**KIRKLEES METROPOLITAN COUNCIL
INVESTMENT & REGENERATION SERVICE**

DELEGATED DECISION TO DETERMINE PLANNING APPLICATIONS

Reference No: 2018/60/92832/E

Description: Outline application for erection of detached dwelling

Drawing Title
**Location Plan and
Existing and Proposed Block Plans**

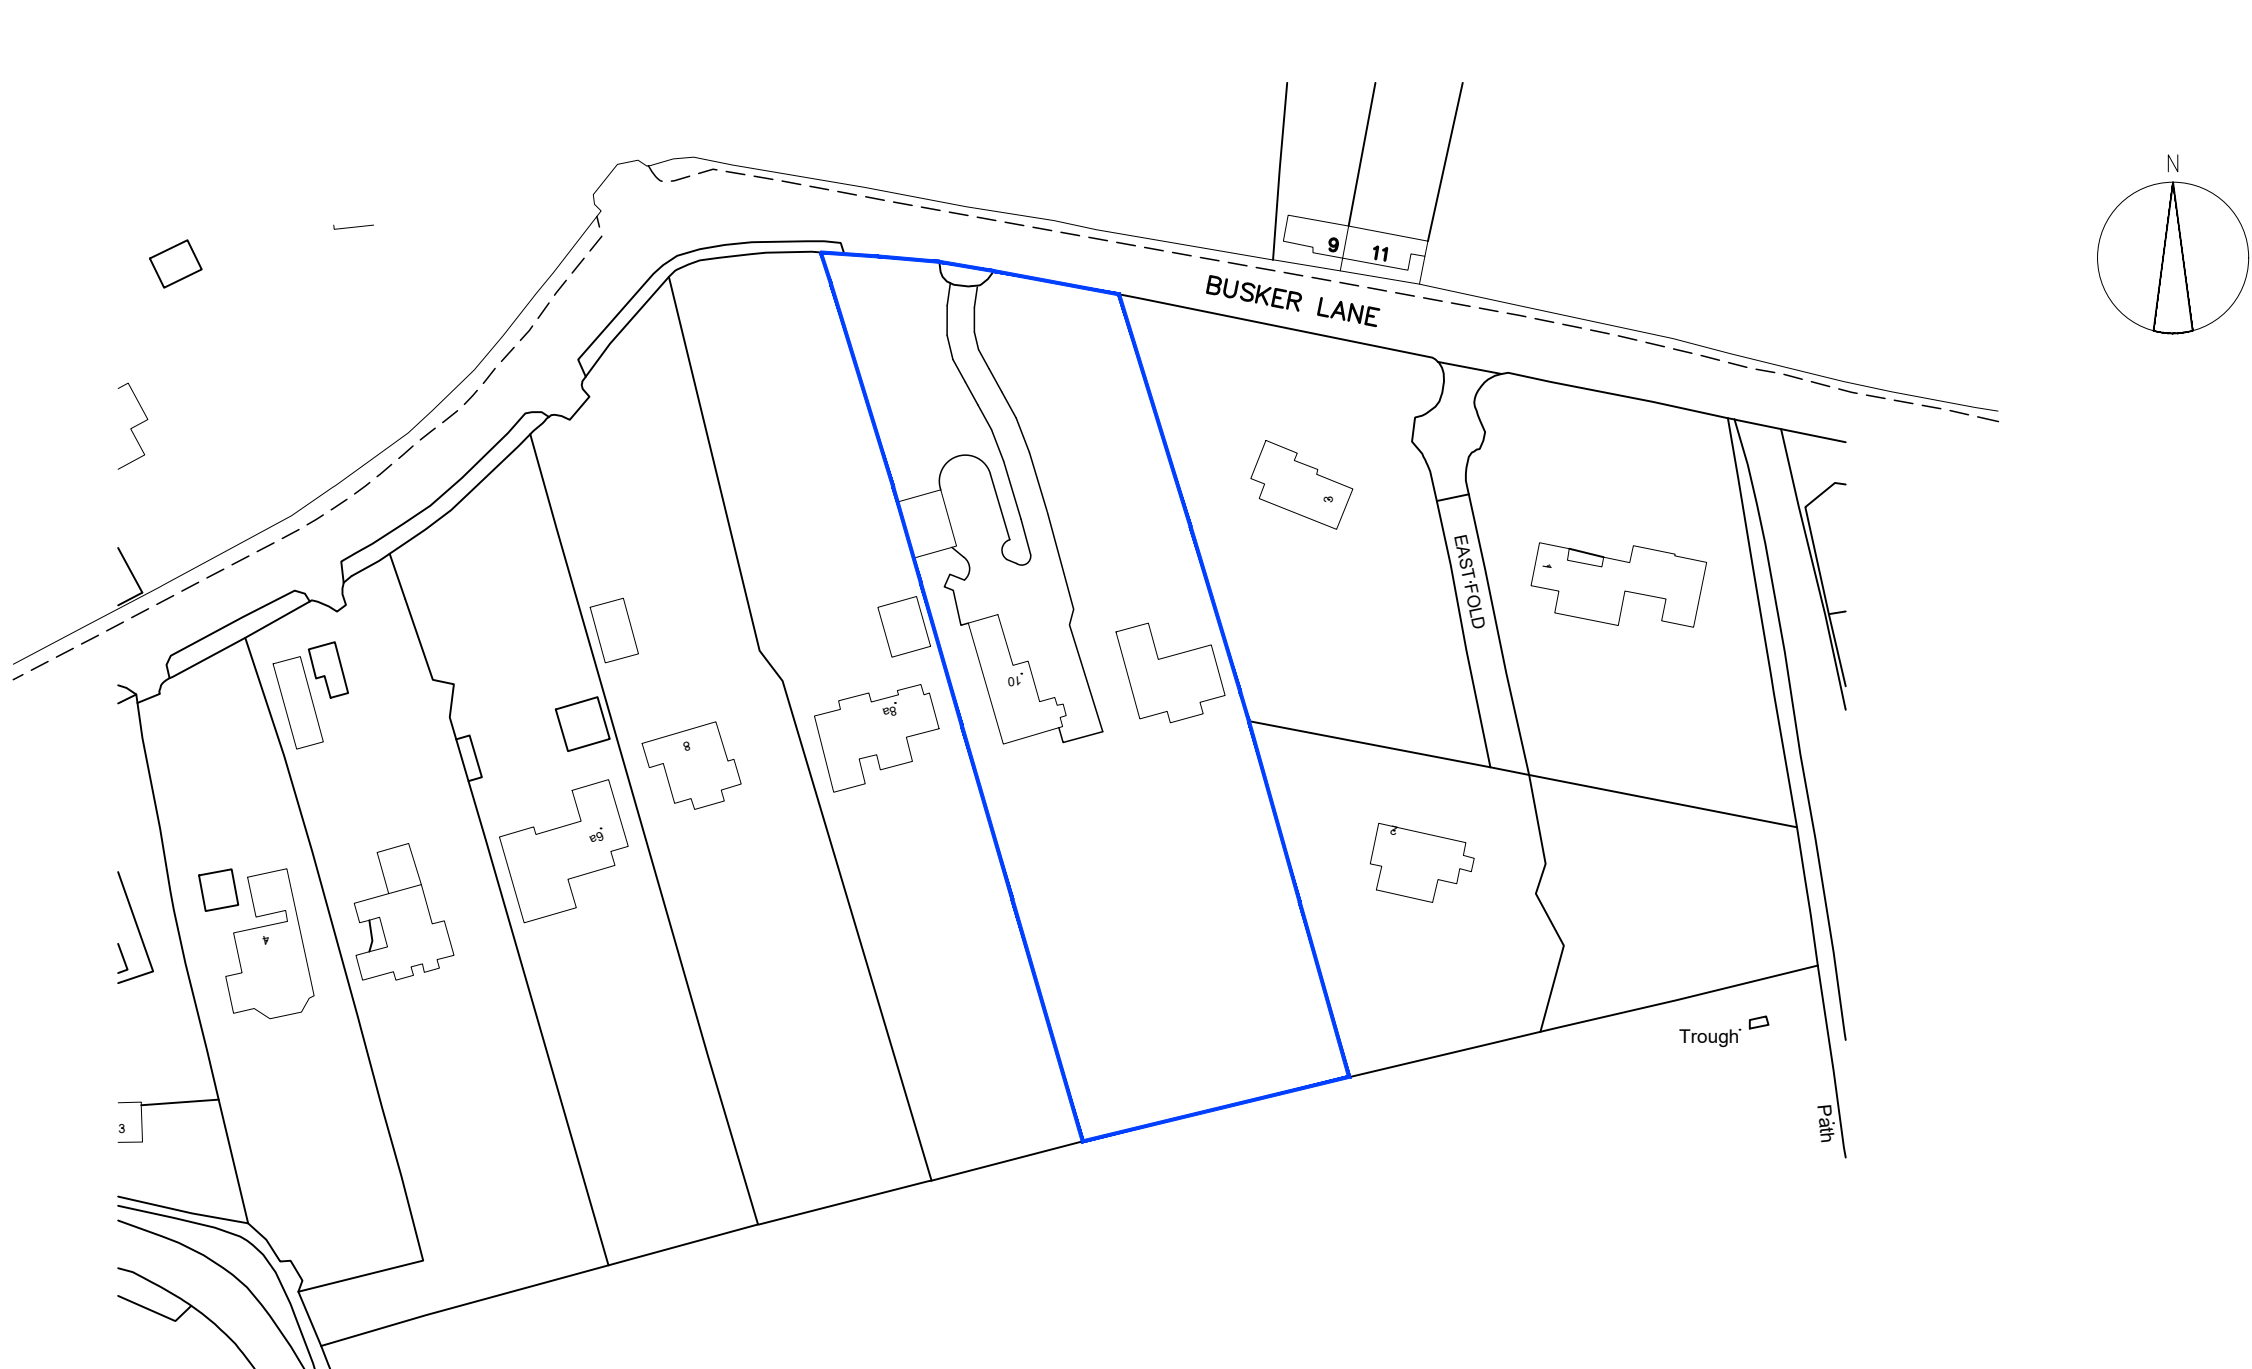
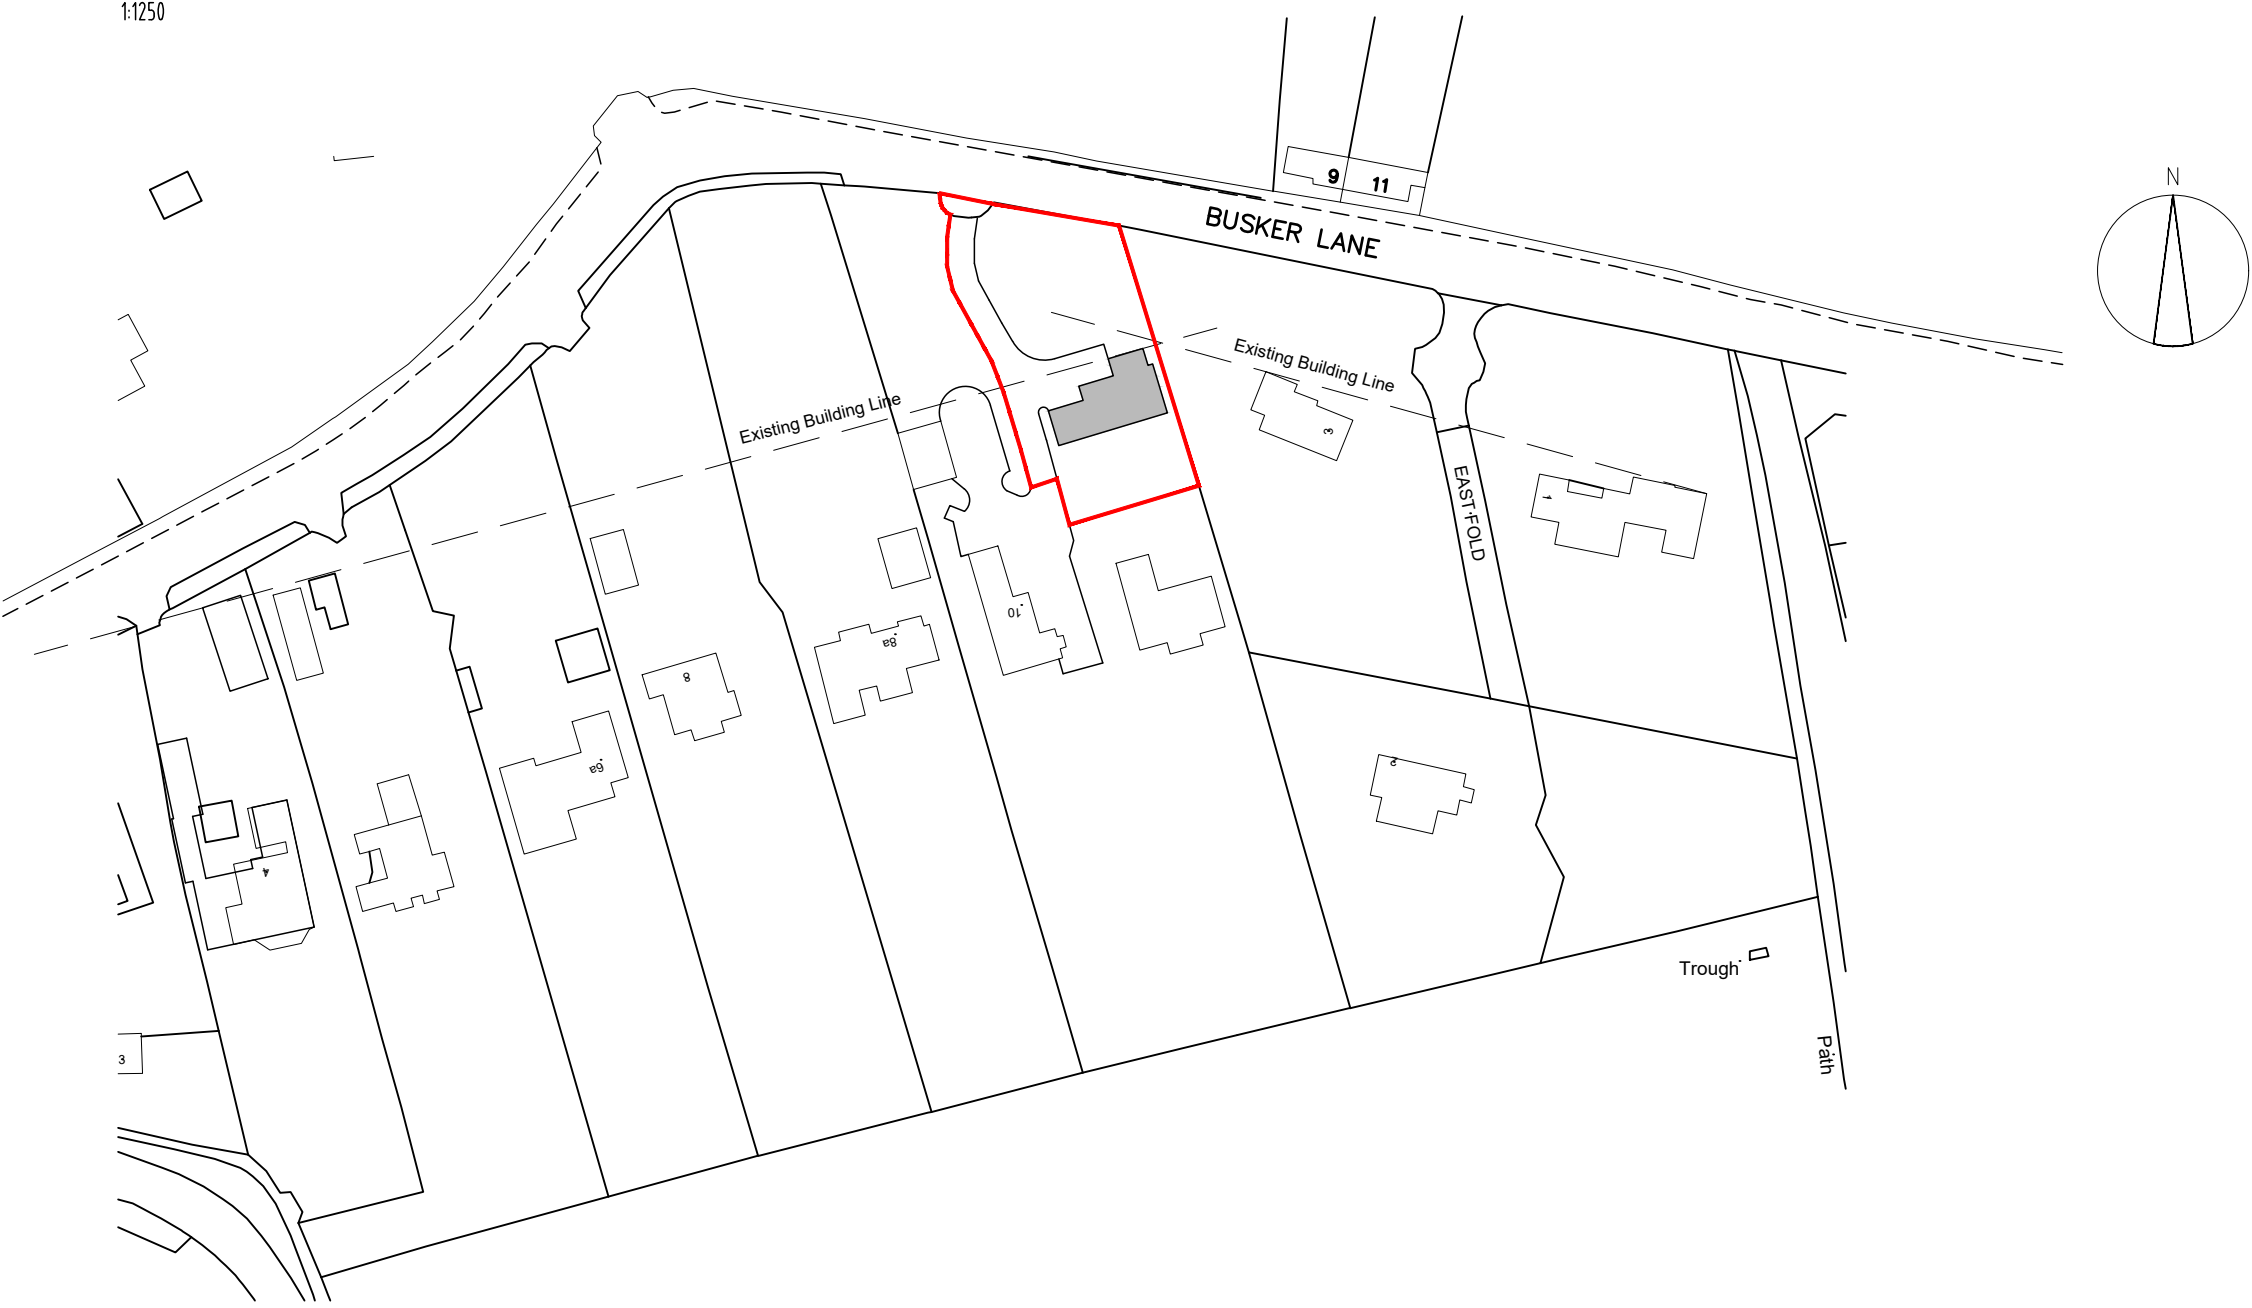
The application site comprises the front garden of Woodley, a large detached property set well back from the road frontage. The site is 0.13ha in size which at a standard density of 35 dwellings per ha could accommodate between 4 and 5 houses. The site is therefore too large to be considered as an infill plot. Nor is it considered that the site is within existing built form as specified by LP59. The application site is the front garden of the house, and while no's. 1 and 3 East Fold are more forward towards the road frontage than Woodley, the new house would extend that pattern, not be within it. Nor can the road frontage be described as built up, as the existing houses are set a very long way back with gardens fronting the road. The site has open fields to the front and a large garden to the west so cannot be said to be largely surrounded by development.

It is possible that a dwelling could be designed so as to be in character with surrounding development however, the introduction of a new building where shown would result in an incongruous feature into this open green belt setting thereby harming the character and openness.

At this outline stage, Highways DM would wish to see improvements to the access to allow vehicles to pass each other where it serves more than one dwelling; a minimum width of 4.5m would be required.

Currently, the sight-lines from the access are substandard, and, given the proposed intensification of use of this site, KC Highways DM would advise that these are improved to the guideline splays set out in Manual for Streets, namely 2.4m x 43m. It is likely this could be achieved by lowering the existing walls and planting nothing taller than 1.0m within 2m of the carriageway edge, then being retained in perpetuity by condition.

It is apparent that there is ample opportunity for adequate off-street parking to be created, but any full application should include parking and turning provision in line with current standards. In this instance the application fails to show adequate visibility and widening and as such is contrary to Local Plan Policy LP21 and LP22.
